Two storey side extension to existing detached house. Conversion of integral garage.
Old Sussex Seafield Road East Preston

Thank you for your internet representation made on 24th March 2019 which has been recorded as '**an objection**' with the comments as follows:

I am commenting on this application on behalf of the East Preston and Kingston Preservation Society.

Client: Mr & Mrs Howells	
Project Address: Old Sussex Seafield Road East Preston West Sussex	
Drawing Title: Proposed Plans, Elevations, Roof Plan and Site Block Plan	
Drawing Number: 1205.02.a	
Scale:	As stated printed @ A1
Date:	05.03.2019

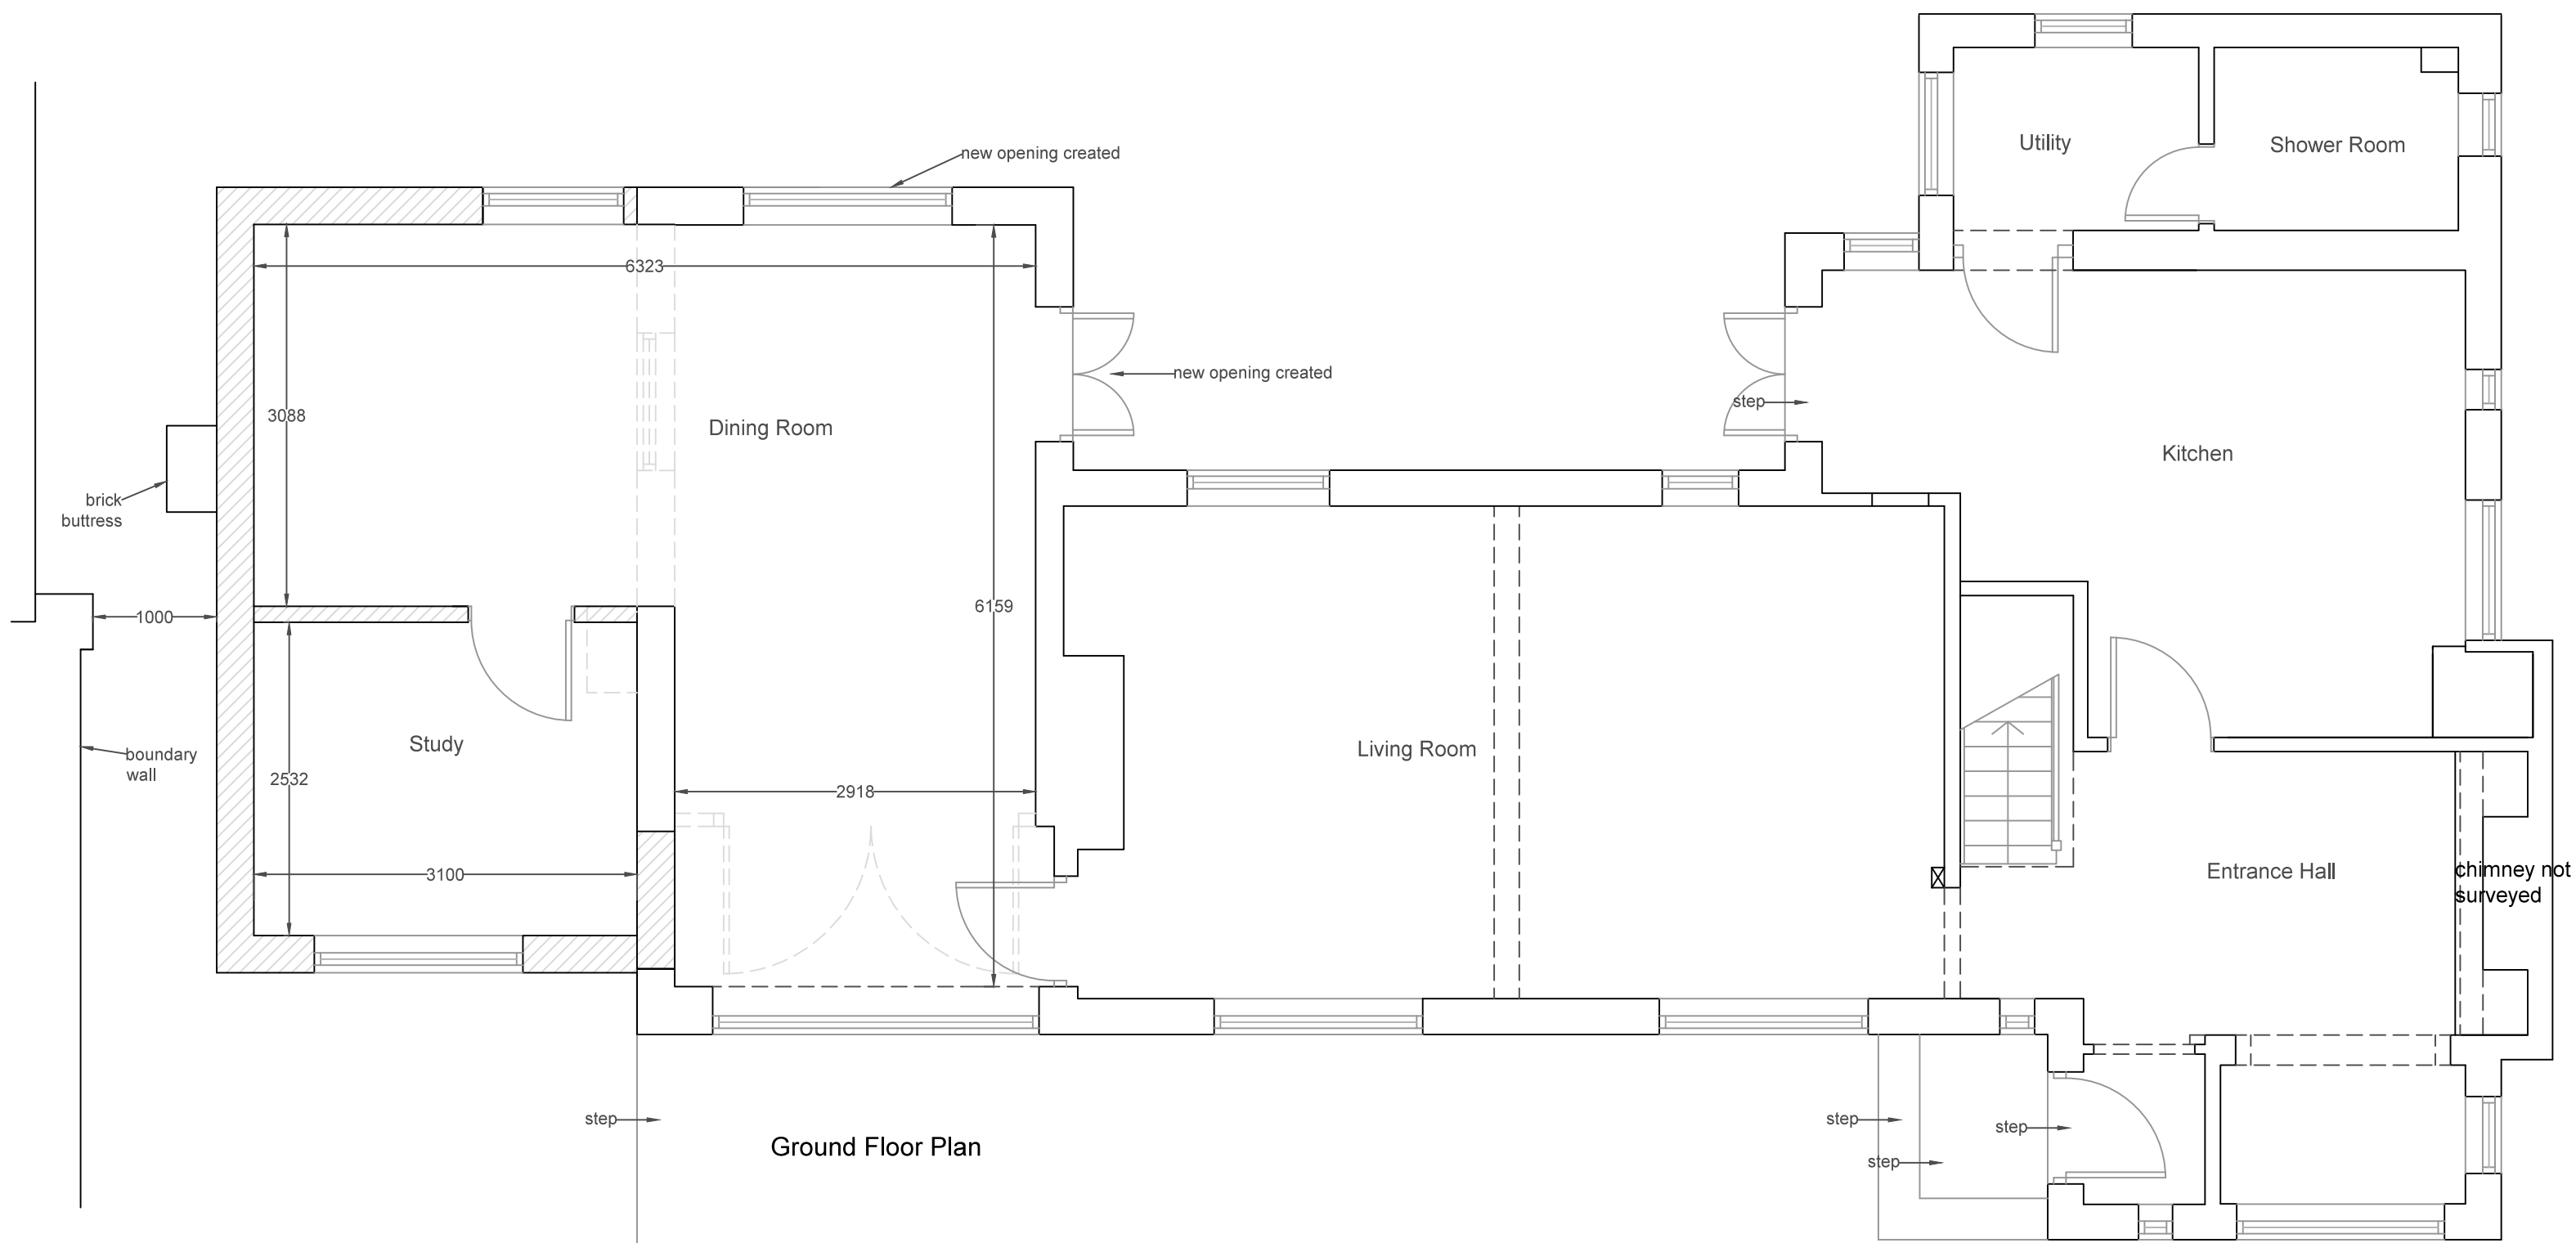
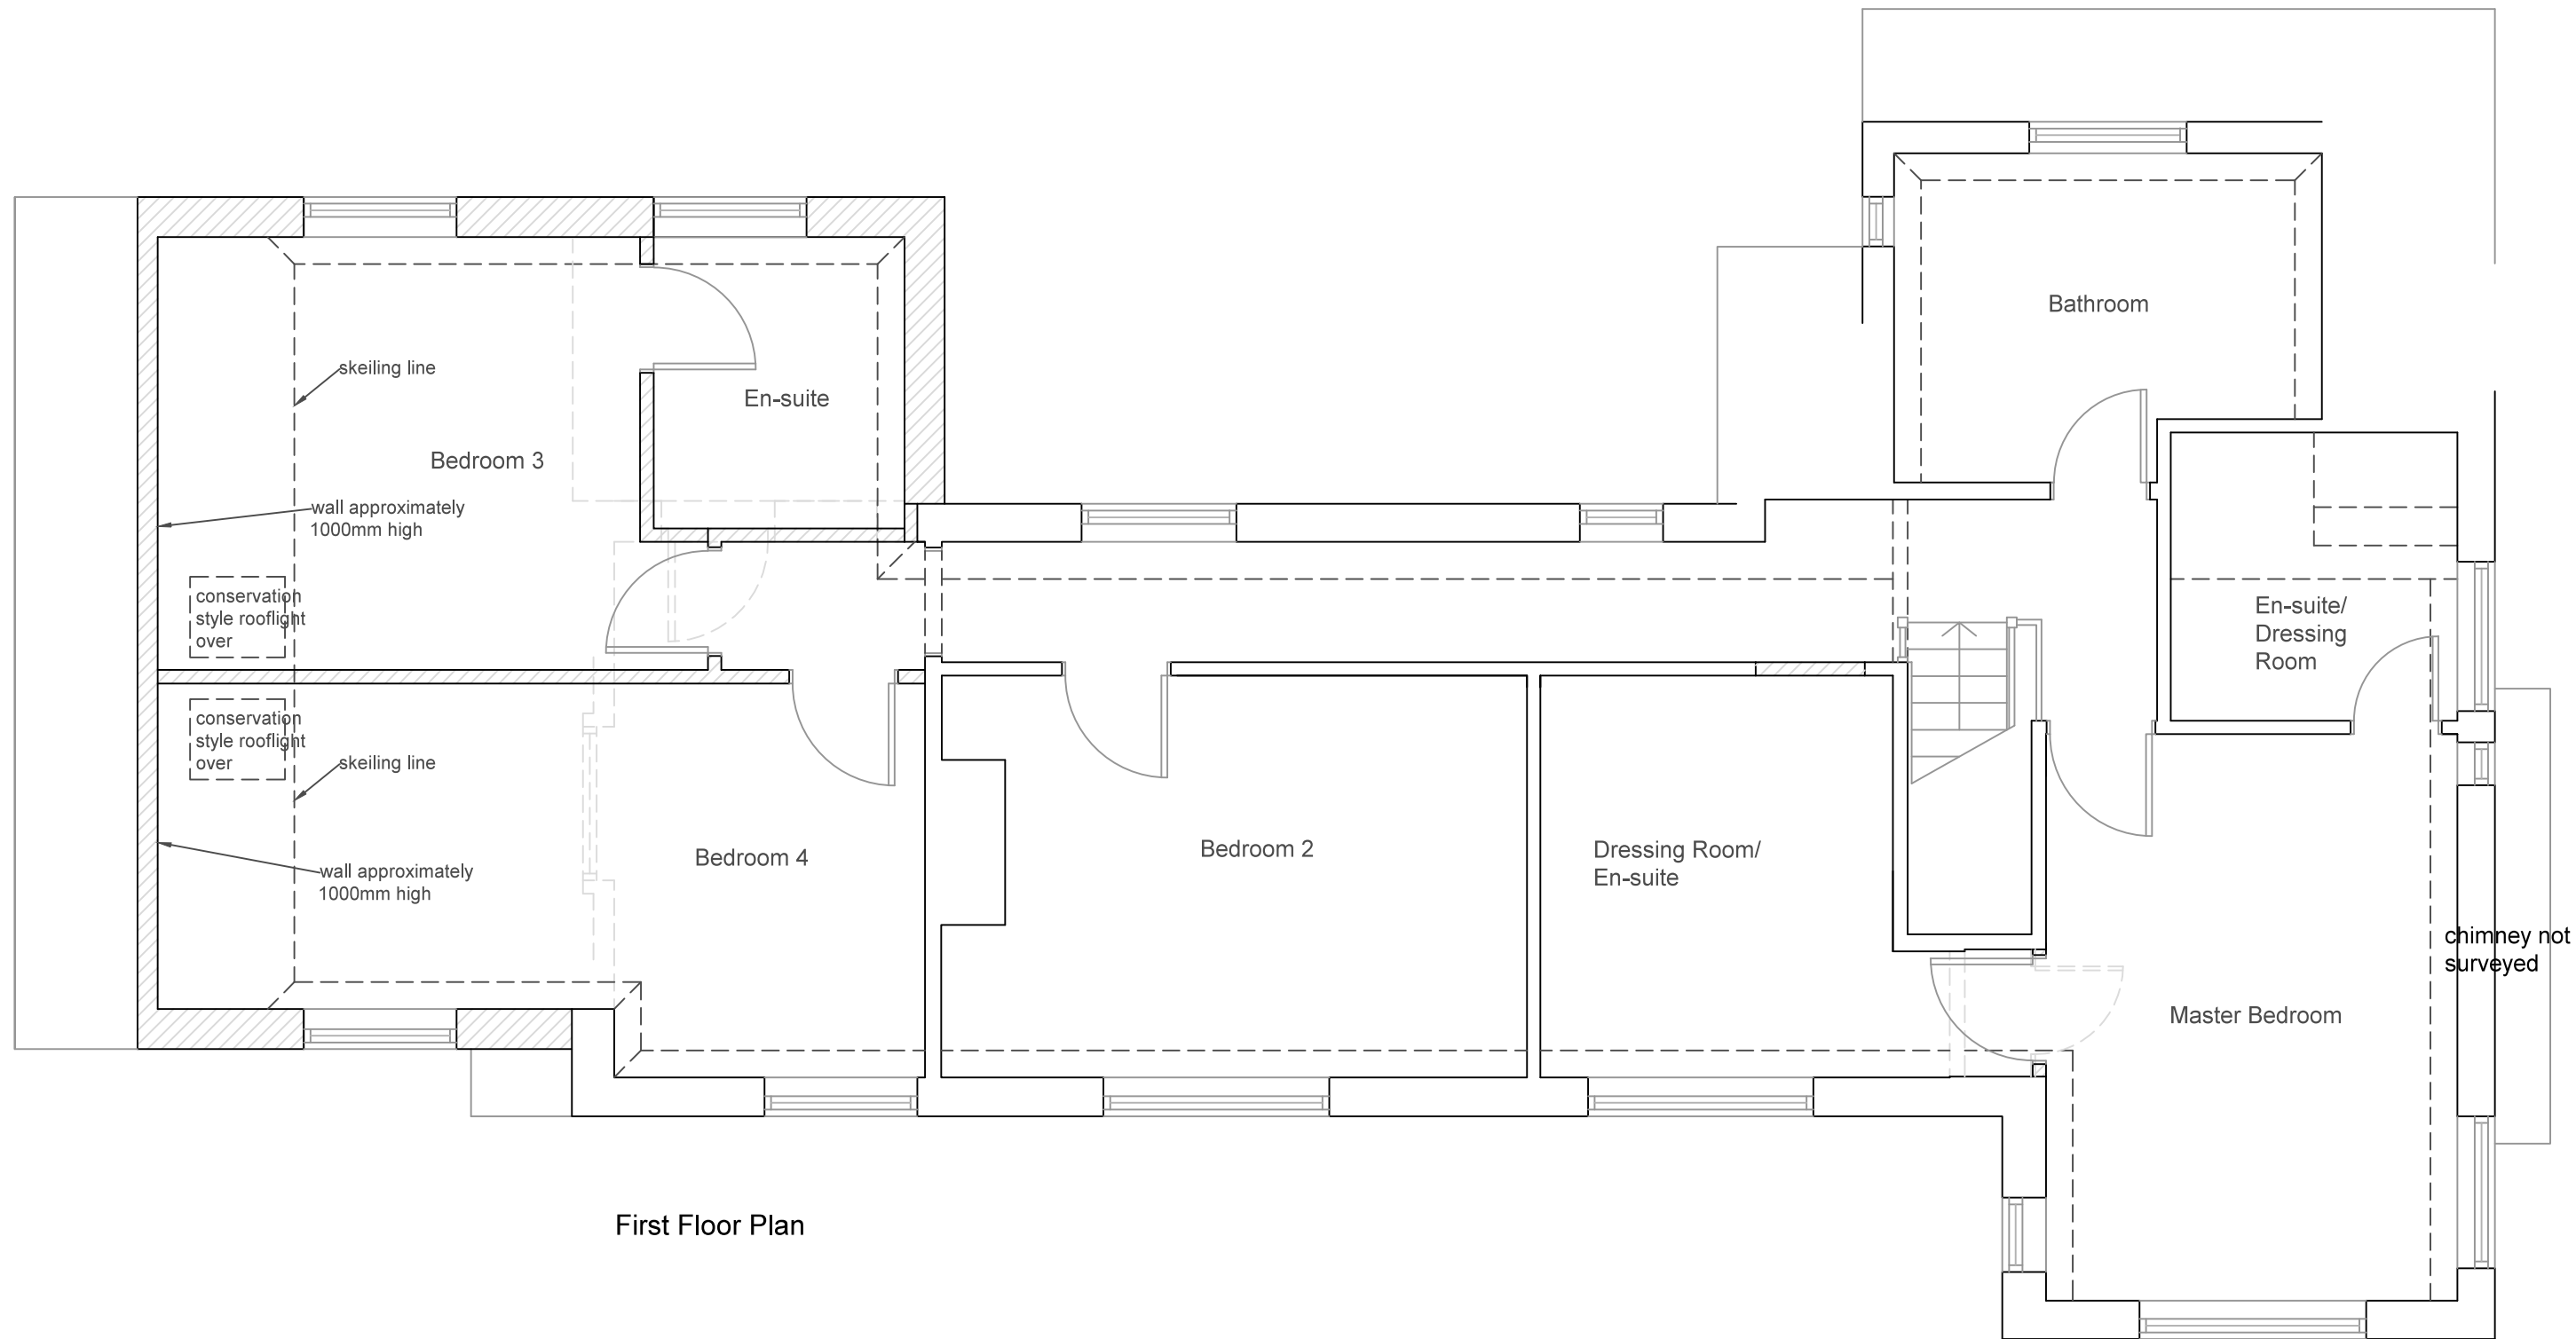
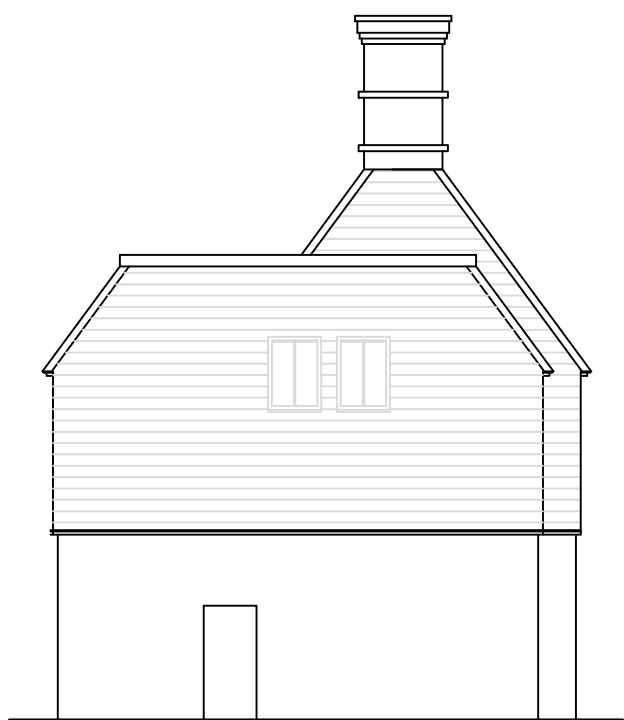
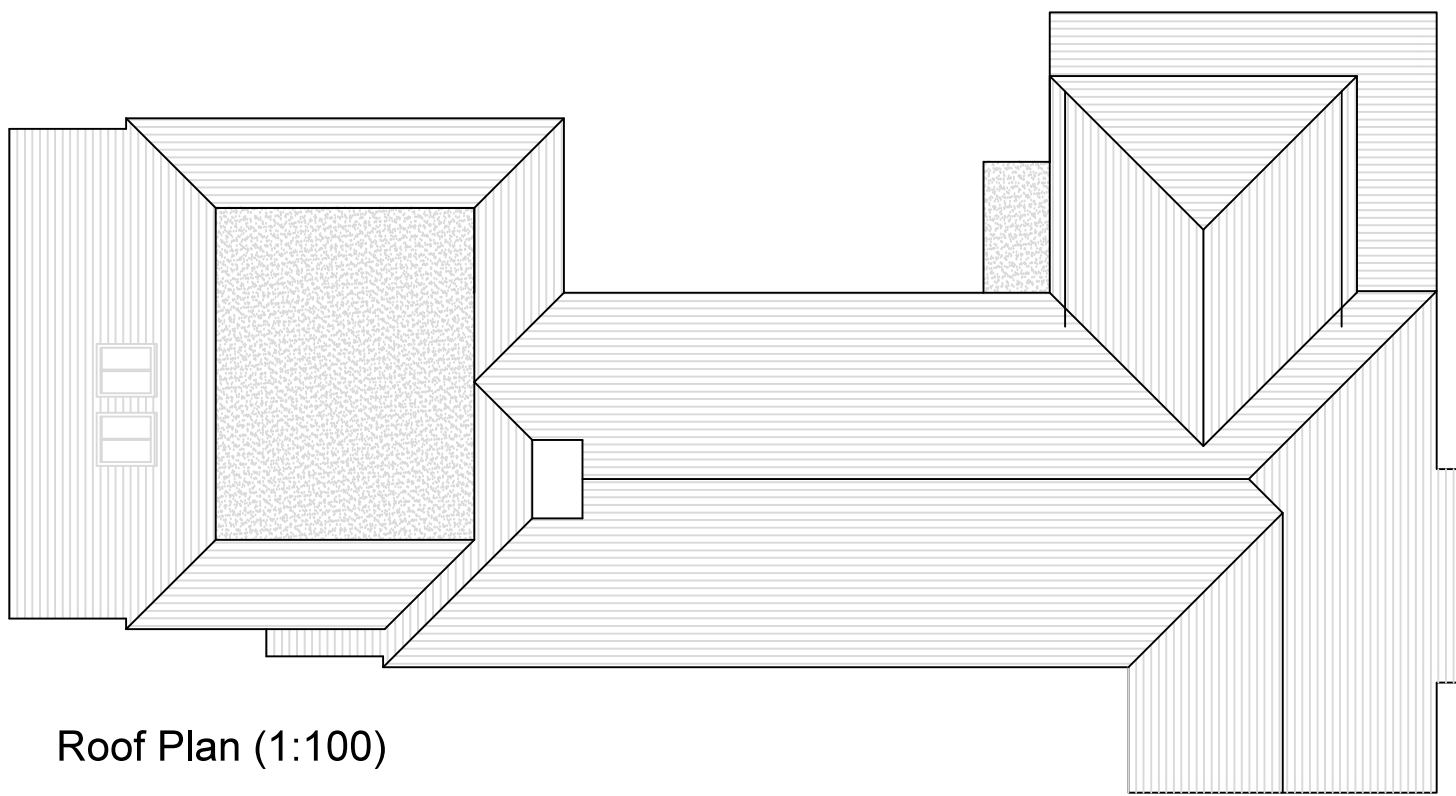
The proposed side extension is much deeper than the present house and its height has been restricted by leaving a large area of the roof flat. The character of the extension therefore differs significantly from that of the original house, and this difference in character will be very apparent at any viewpoint other than dead ahead. The difference in roof height, created by cutting off the top of the roof of the extension, would emphasise that the extension was not part of the original house.

These features would render the extension in breach of Policy D DM4 of the Arun Local Plan, because the extension would not be visually integrated with the existing building; and with Policy 1 of the East Preston Neighbourhood Plan, because the extension would not reflect the character and scale of surrounding buildings, and would not look as if it was part of the original design of the house.
